Subject: New comments for application 19/01410/REM

New comments have been received for application 19/01410/REM at site address: Cotswold Country Club Bunkers Hill Shipton On Cherwell
OX5 3BA

NOTE: This is not an objection to the Planning application as such, but an objection to aspects of the detailed plans submitted by the developer (Keble Homes). Some of the questions have recently been asked of the developer, but as yet have received no response. We are therefore seeking answers and clarifications on the following concerns:

**Project No**  
 PLANTING PLAN (SHEET 1)

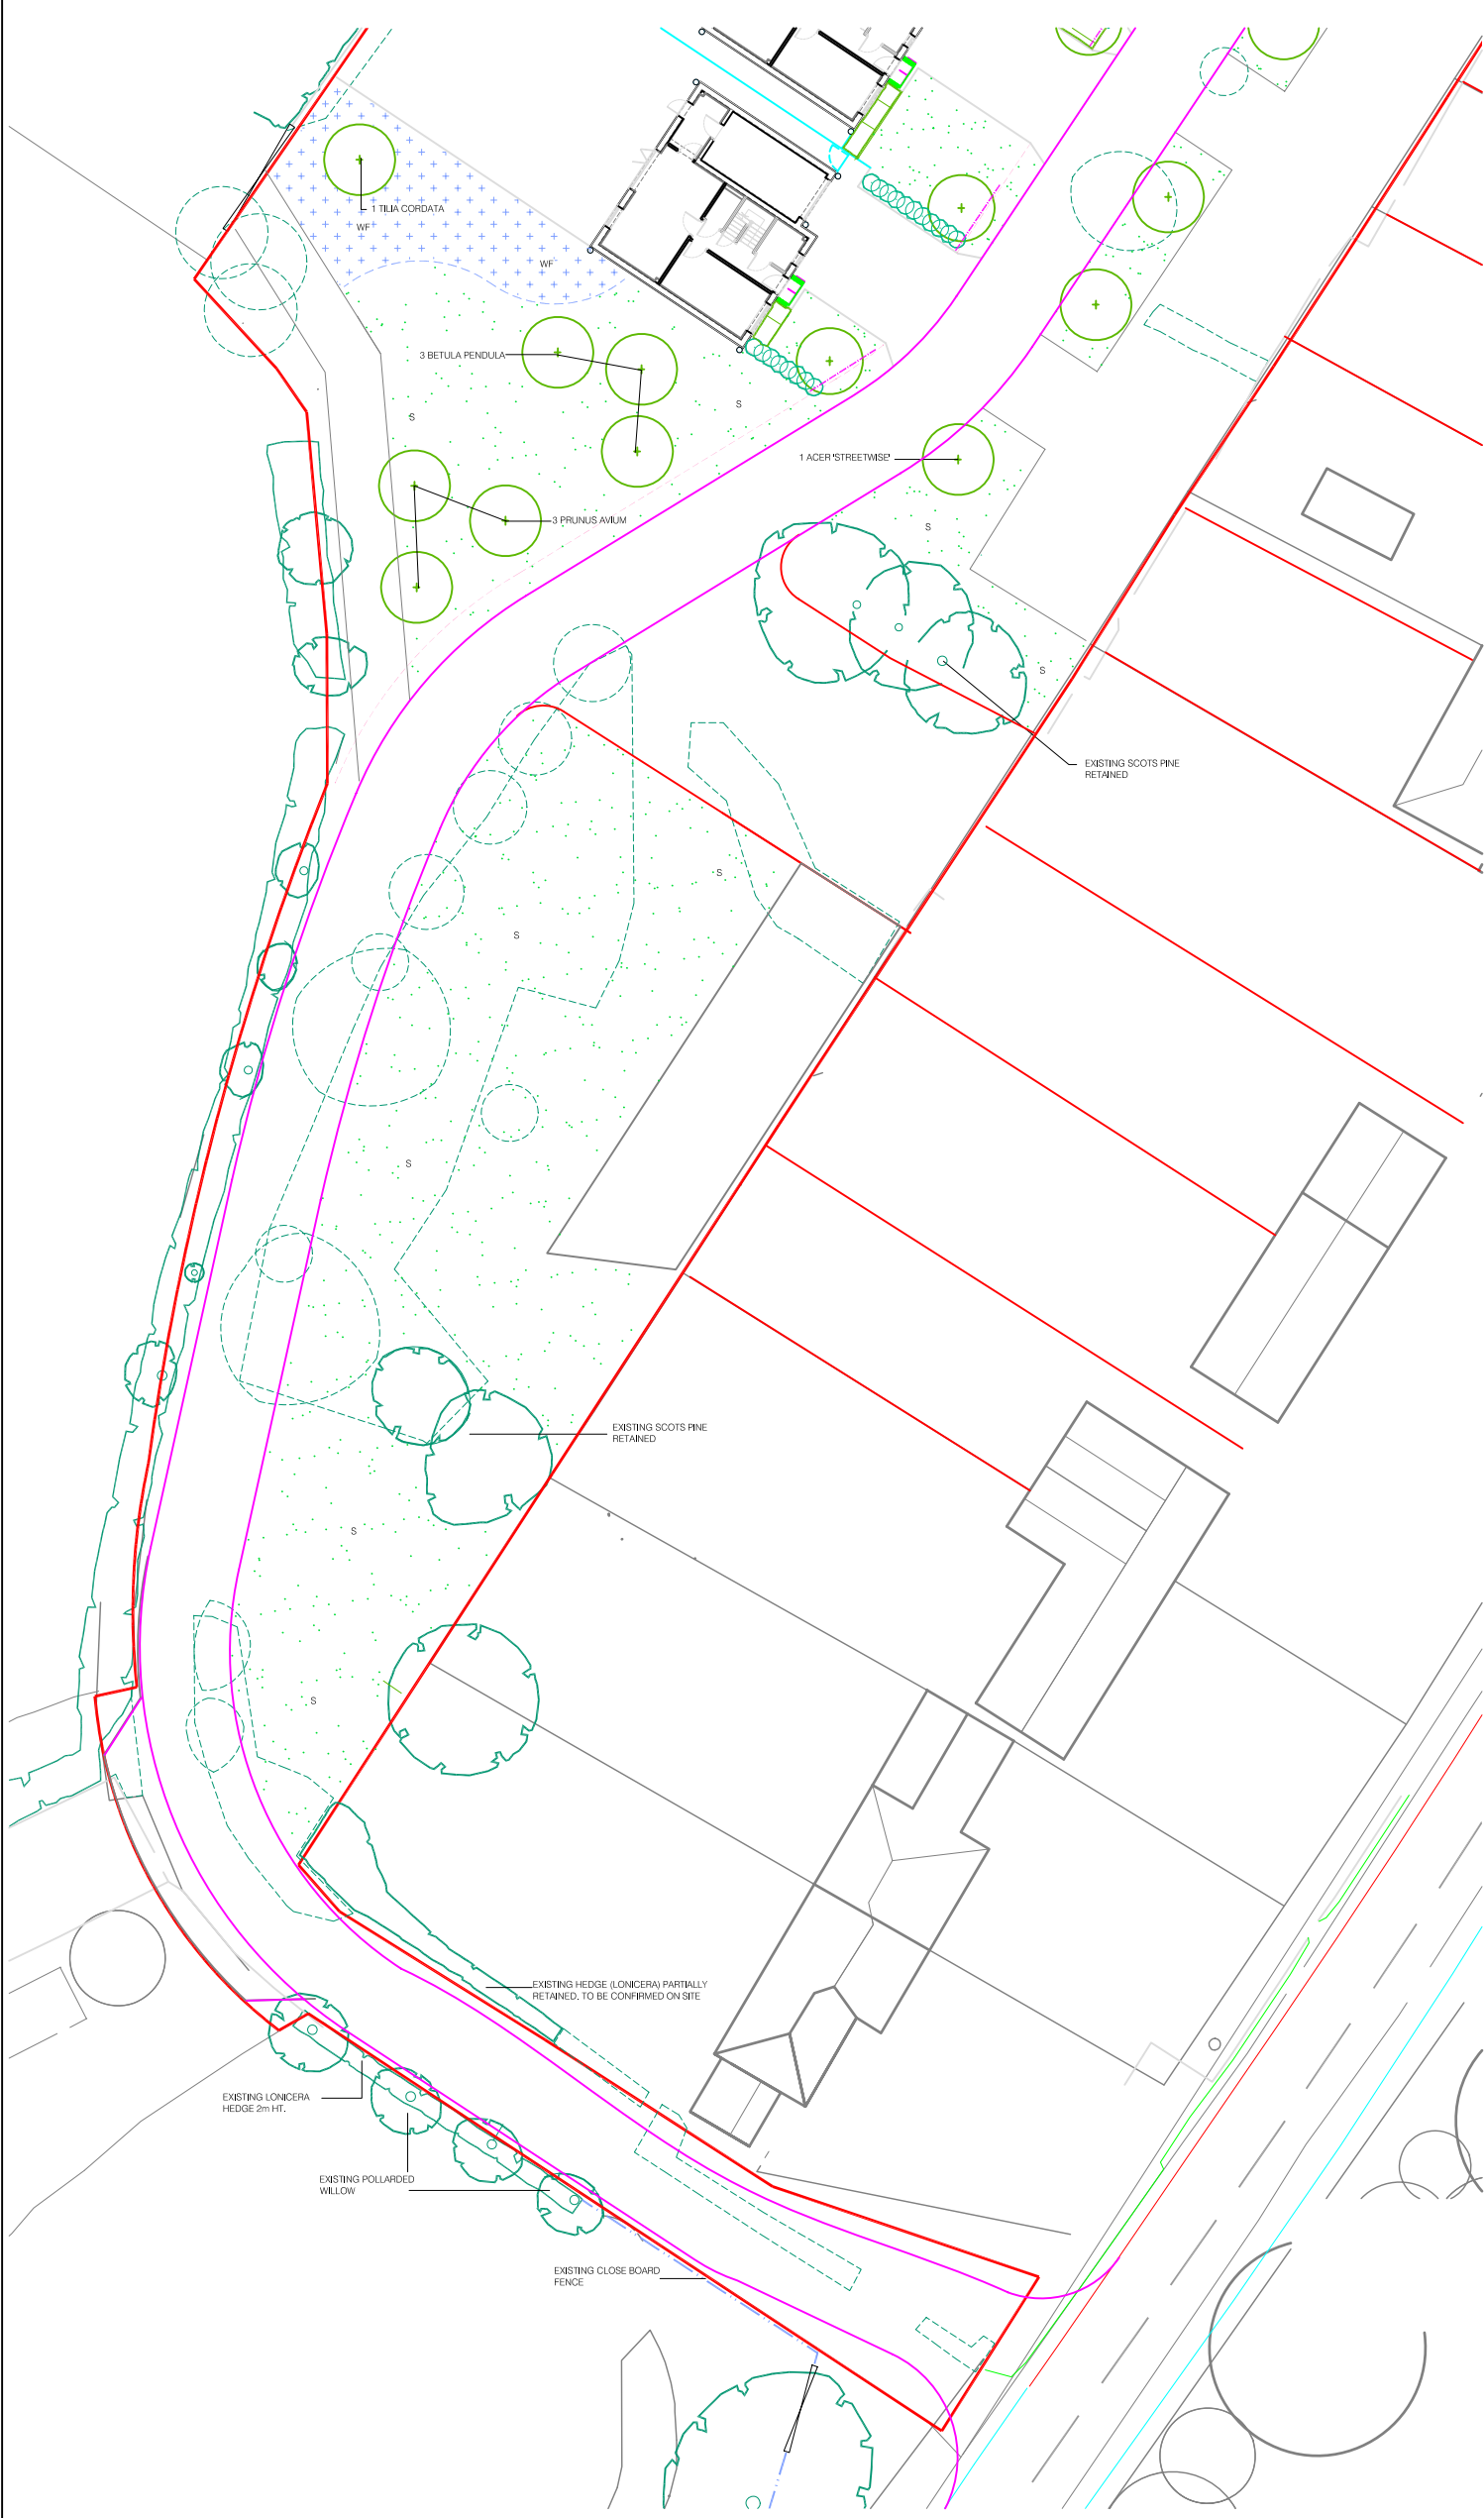
- We have a number of concerns regarding the proposed screening shown on the plans between the new access road and the existing properties, which is shown on BHMC-owned land that is subject to the easement.

o Width of screening shown will restrict/hamper access by existing residents to rear of their properties, and will considerably hamper parking outside of existing properties.

o Plans show trees/screening being planted along the existing BHMC owned track, which will then force existing residents to use the new road for access. As this is not BHMC-owned land, this could leave existing residents open to potential charges and/or access restrictions imposed by the developer, or developer-appointed management company, at some point in the future.

o In addition, the plans show trees being either planted or removed on non-easement BHMC-owned land. There has been no consultation with residents/BHMC from the developer on this.

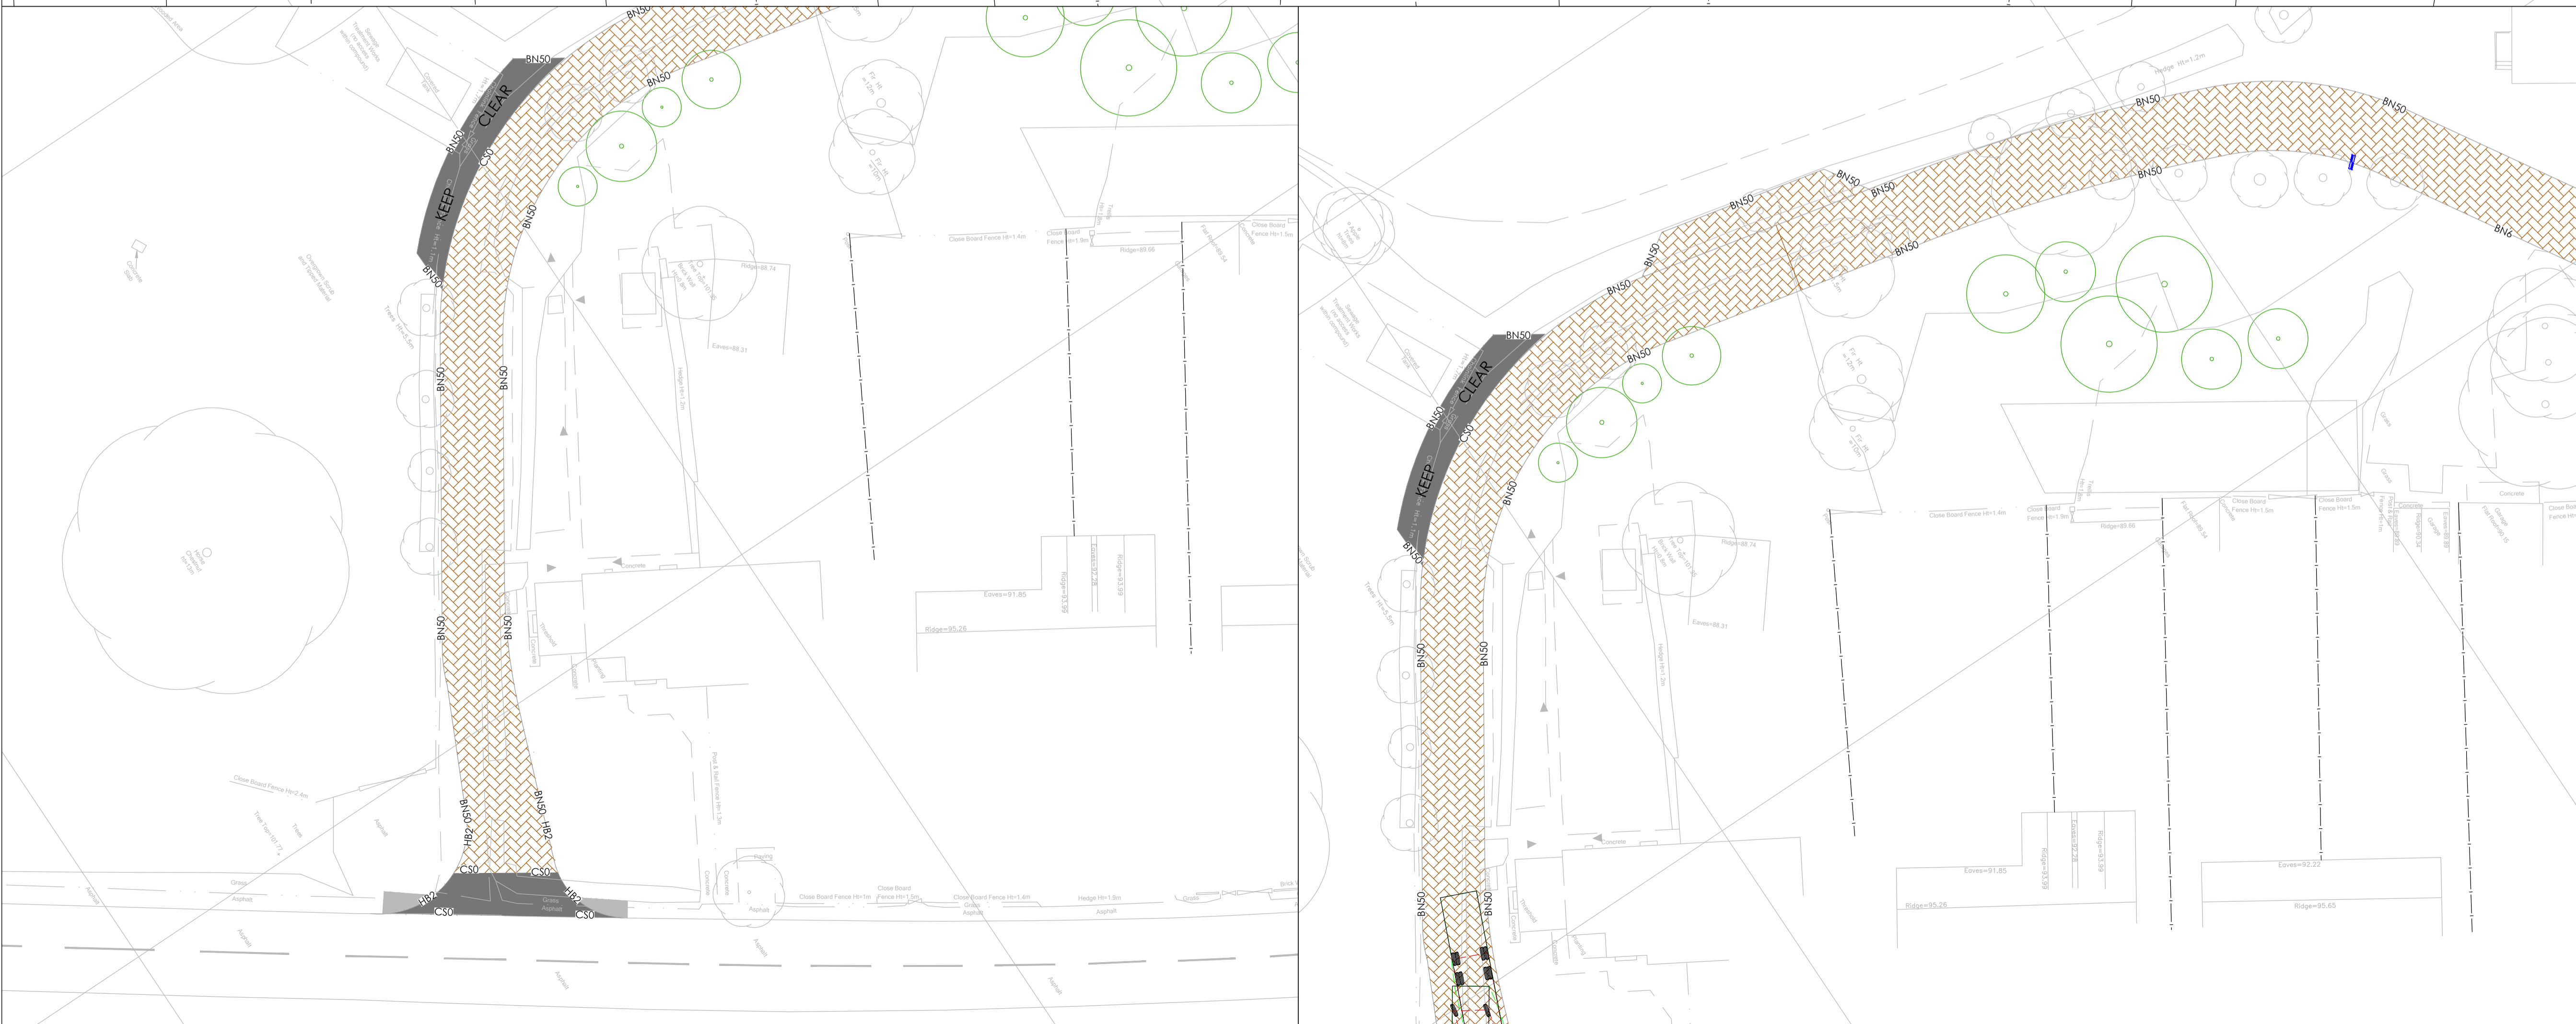
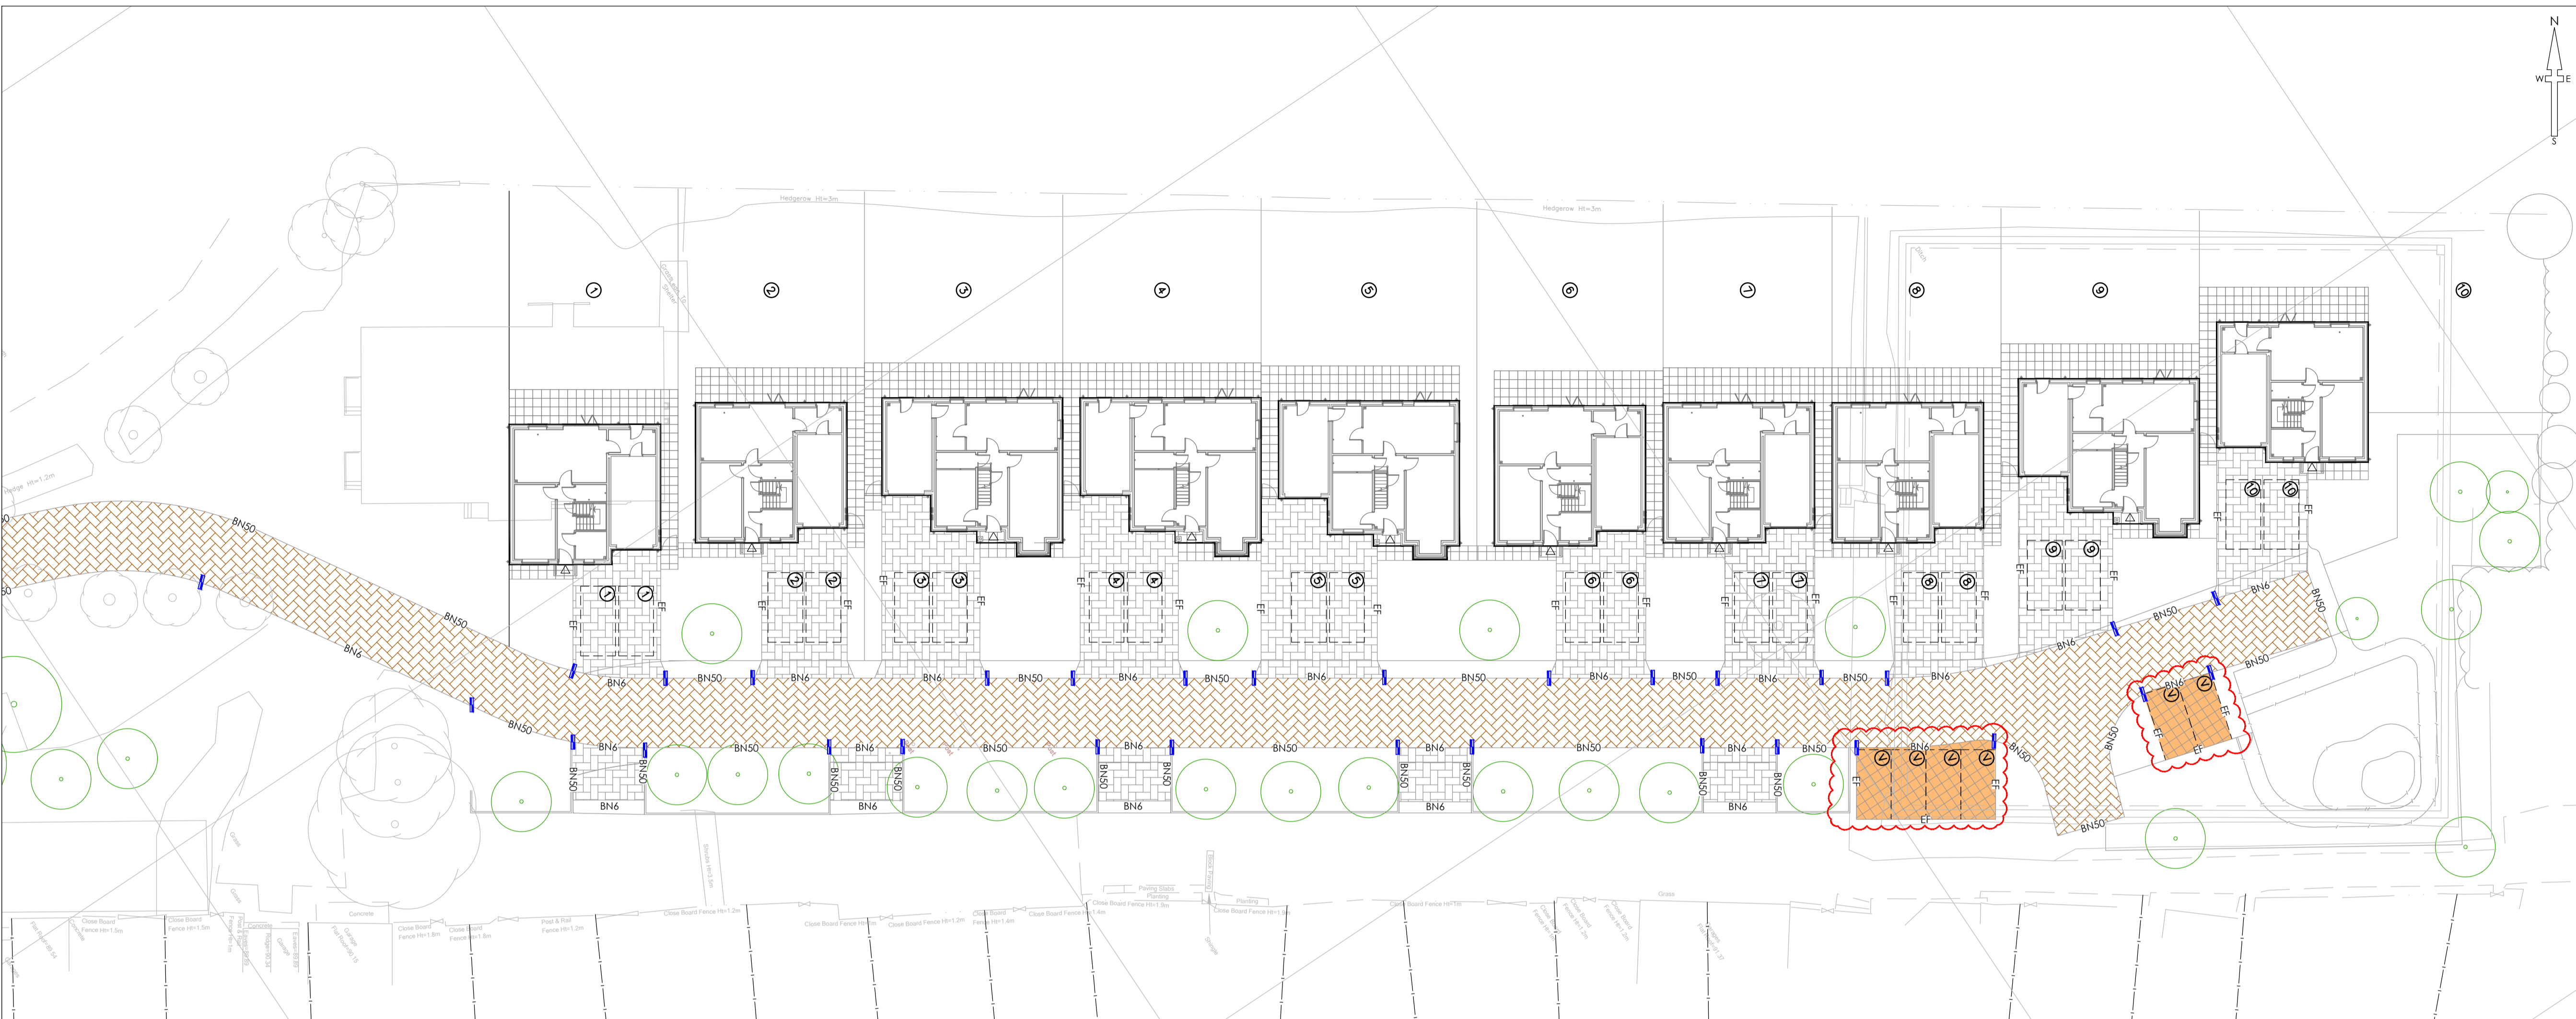
- One of the detailed plans submitted by the developer refers, in the Notes Section, to street lighting but street lights are not marked, or identifiable on the plans.

Street lights have, to date, never been mentioned in any previous plans discussions or earlier consultations, and we strongly object to street lighting in this rural community.
